SNPA ExQ1 Responses

Question 17.5 – SNPA and NRW raise concerns around under-reporting of significant effects. Please identify specifically where your concerns lie, with supporting reasons for this

Question 17.6 – SNPA’s RR makes reference to visual impacts from specific points within the National Park, such as from Carnedd Llywelyn and the Carneddau as a whole. Noting that VP10 is from Carnedd Llywelyn and VP is from Foel Fras;

RWE Renewables UK
Swindon Limited

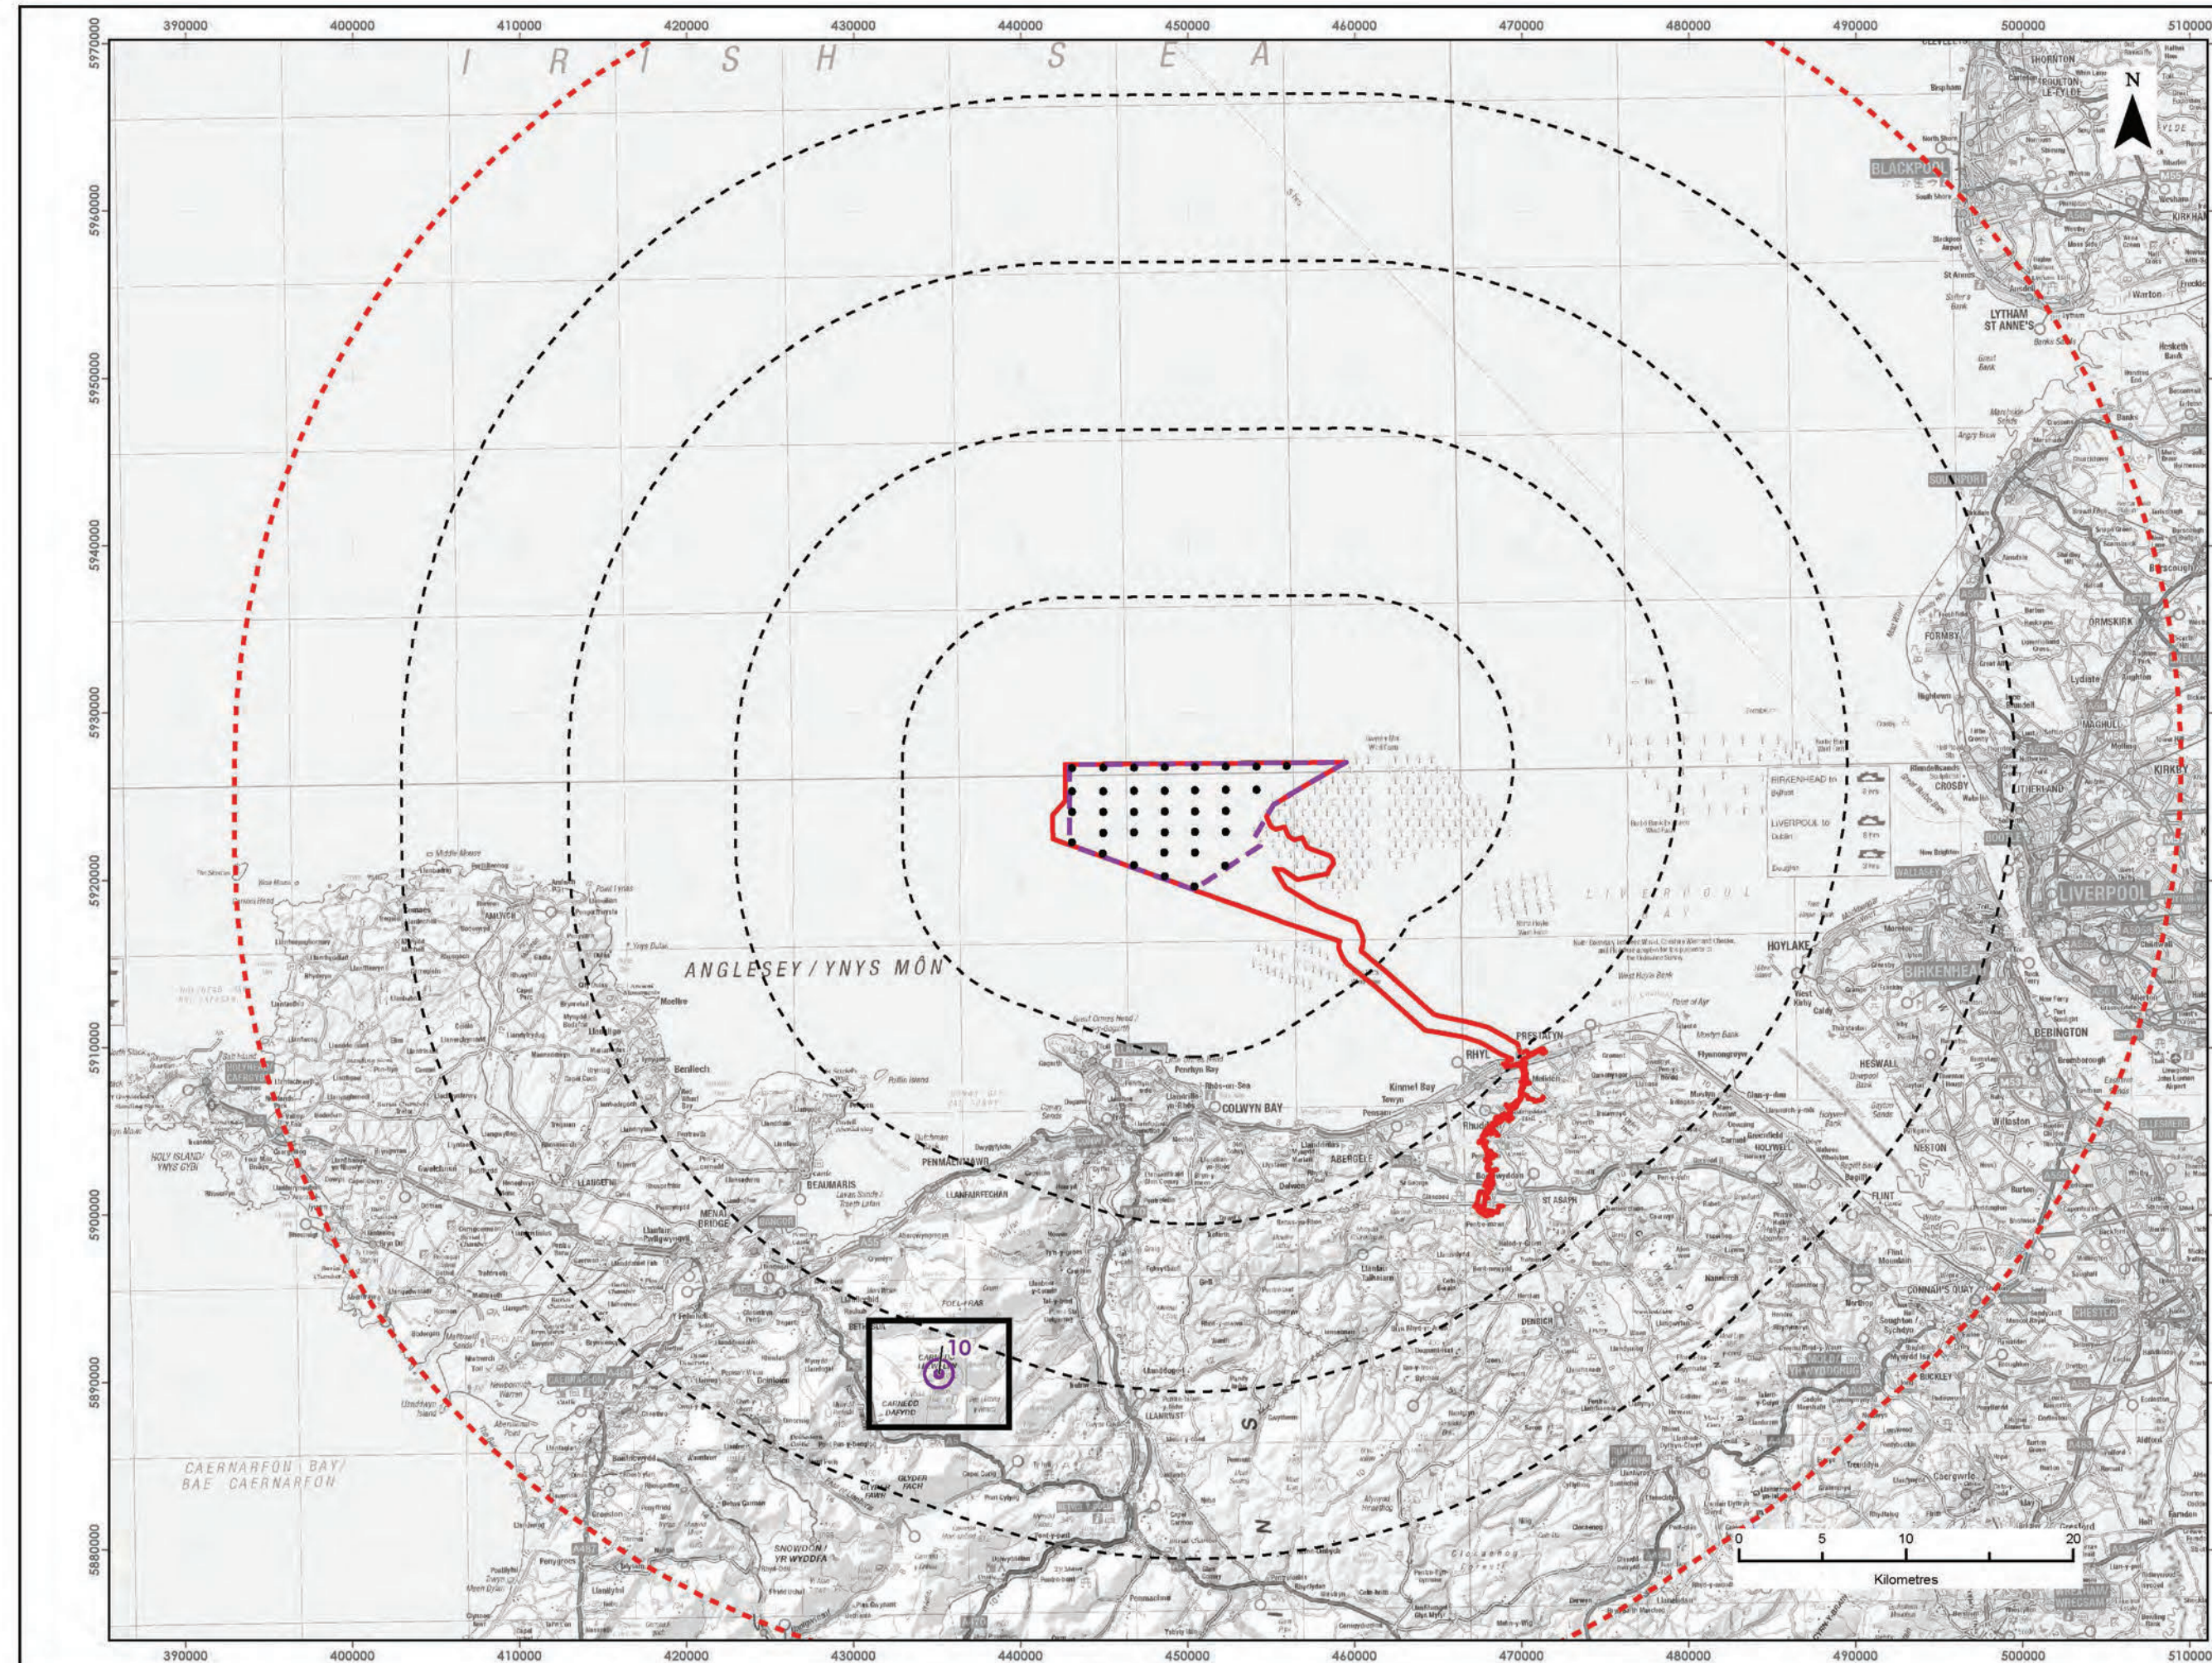
- The PEIR found significant effects at four of these, while we queried the finding of non-significant at VP36 Tal-y-Fan. Effects on the closer viewpoints 12 and 40 are recorded as major- moderate in the ES, with the more distant viewpoints 10 and 38 being moderate. A moderate-minor and non-significant effect is recorded at VP34 Snowdon Summit. The assessment for VP36 Tal-y-Fan is stated to be moderate but not significant. We suggest that, although close to the borderline, this should be identified as significant. We note that effects at VP38 Foel-fras are moderate (significant), on a very similar but more distant view. We highlight an inconsistency in the sensitivity assessment for VP36 that may account for this

- a) **Is SNPA satisfied that these viewpoints are representative of this part of the National Park (ie the Carneddau);** Yes
- b) **Does SNPA agree with the Applicant's assessment that residual effects from these viewpoints would be moderate adverse and significant;**
Agree that these viewpoints in particular would be moderate (significant). As per the findings of the LUC review however we believe that Tal y Fan should also be significant
- c) **Does SNPA agree with the Applicant's assessment that residual effects on the SNPA Landscape Character Area (LCA) 02; Carneddau Range would be minor moderate adverse and not significant?** In terms of the area/LCA as a whole, yes. Specific viewpoints (ie Carnedd Llywelyn) within the LCA would be 'significant' however (as the authors note).
